21 November 2013

**Notifications under Circular 01/2001, Circular 08/2009 &
T&CP (Development Management Procedure) Order 2010**

**BEVIN BEVIN & CO LTD., RIVER ROAD, ARUNDEL, WEST SUSSEX BN18 9DH
Application No AB/104/13 and AB/105/13/L**

Drawing
**Location Plan
Site/Roof Plan**

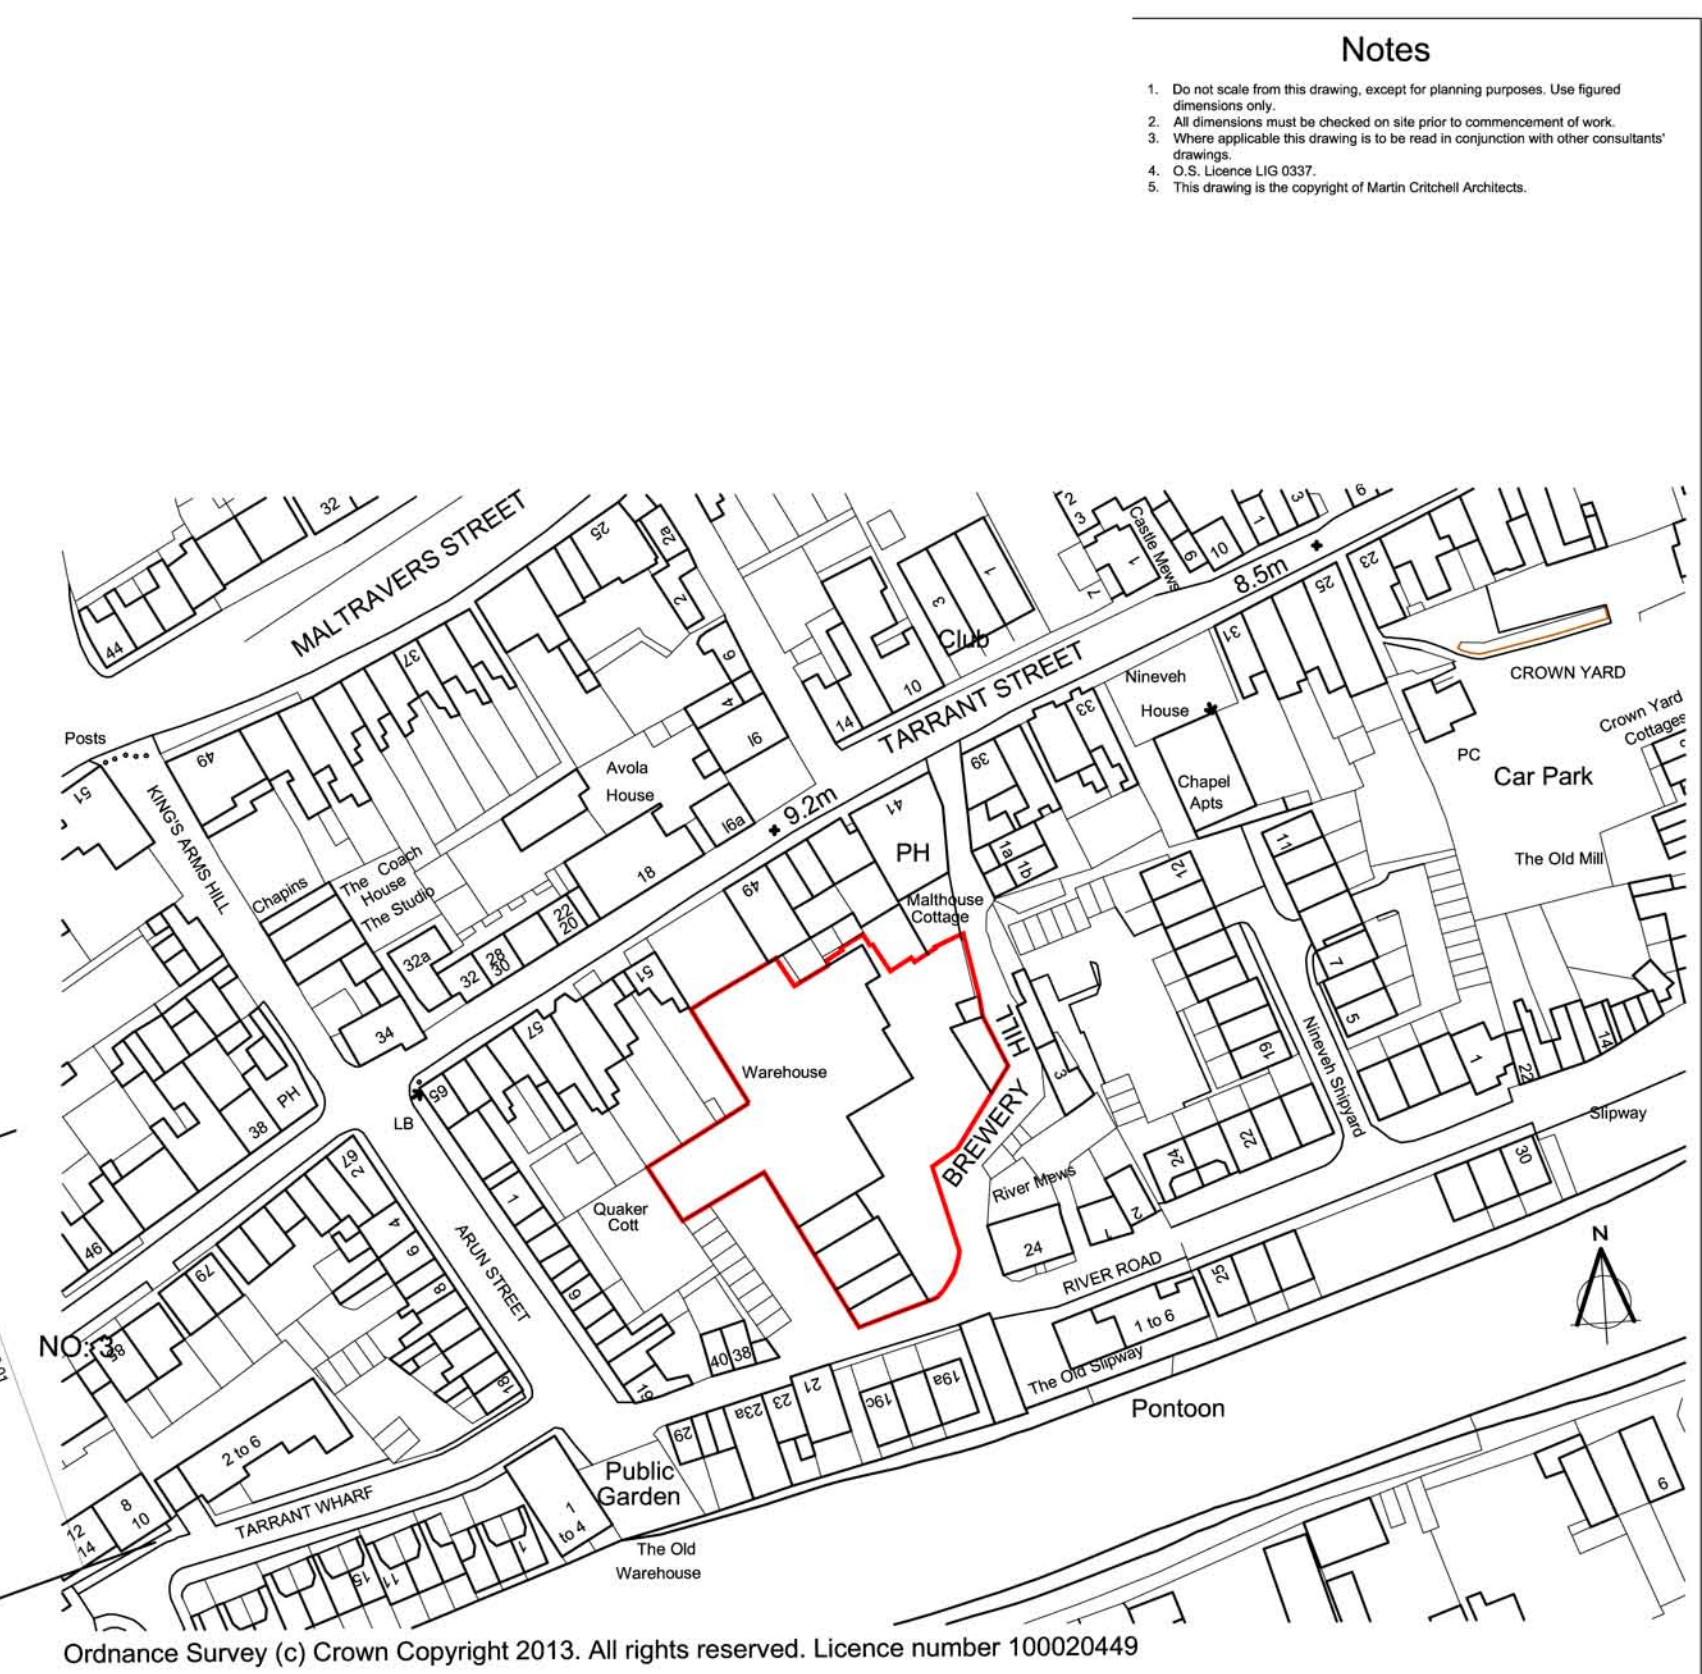
The loss of the southernmost range of 'building 4' as identified in the heritage statement is regrettable. We understand that this building presents challenges for conversion because of the depth of the floor plan, and the need for natural daylight to units; however it is identified within the heritage statement as being highly significant. This building is identified as the 'Tun Room' and as such represents an important part the brewing process. It has a number of interesting surviving features, including original stone and brick floor finishes, cast iron columns, and barrel storage areas, and louvered windows, and it is unclear how much of this will be retained, or be expressed in the final finishes of the building. If the local authority is minded to accept the loss of the southernmost range, and the subdivision proposed, it will be important that stringent recording conditions are imposed. Extensive glazing is proposed in the new southern elevation of buildings 5, 6, and the east and west elevations of building 7, albeit partly concealed behind enclosed boundary walls. This approach is a significant departure from the character and appearance of the existing 'sheds', and should be rationalised.

The proposed design concept, which uses the existing roof form as its design cue, is not in itself objectionable, however, while the arc of the existing roof has been used, it has been pivoted so that the roof would be much higher than the existing shed, sitting high above the boundary wall of the site, with again extensive glazing and balconies proposed, which do not conform to the industrial character. If the floorspace required cannot be achieved within the constraints of this design, it may be preferable to adopt the warehouse typology of pitched roofs and traditional materials elsewhere on the site, in order that roofs can be kept lower, and be less intrusive to the conservation area.

Finally, the redevelopment of building 12 is not of concern to us, provided that the boundary wall behind is appropriately repaired and retained. The proposed development takes the form of an undercroft for parking, with living accommodation above. This is indicated as being supported by slender columns, which while having the advantage of allowing views through to the boundary wall, has the peculiar result of the accommodation above apparently 'floating'. We suggest that a more deliberately solid construction would better enhance the character of the conservation area. The eaves line could we feel also be reduced so as not to protrude above the boundary wall.
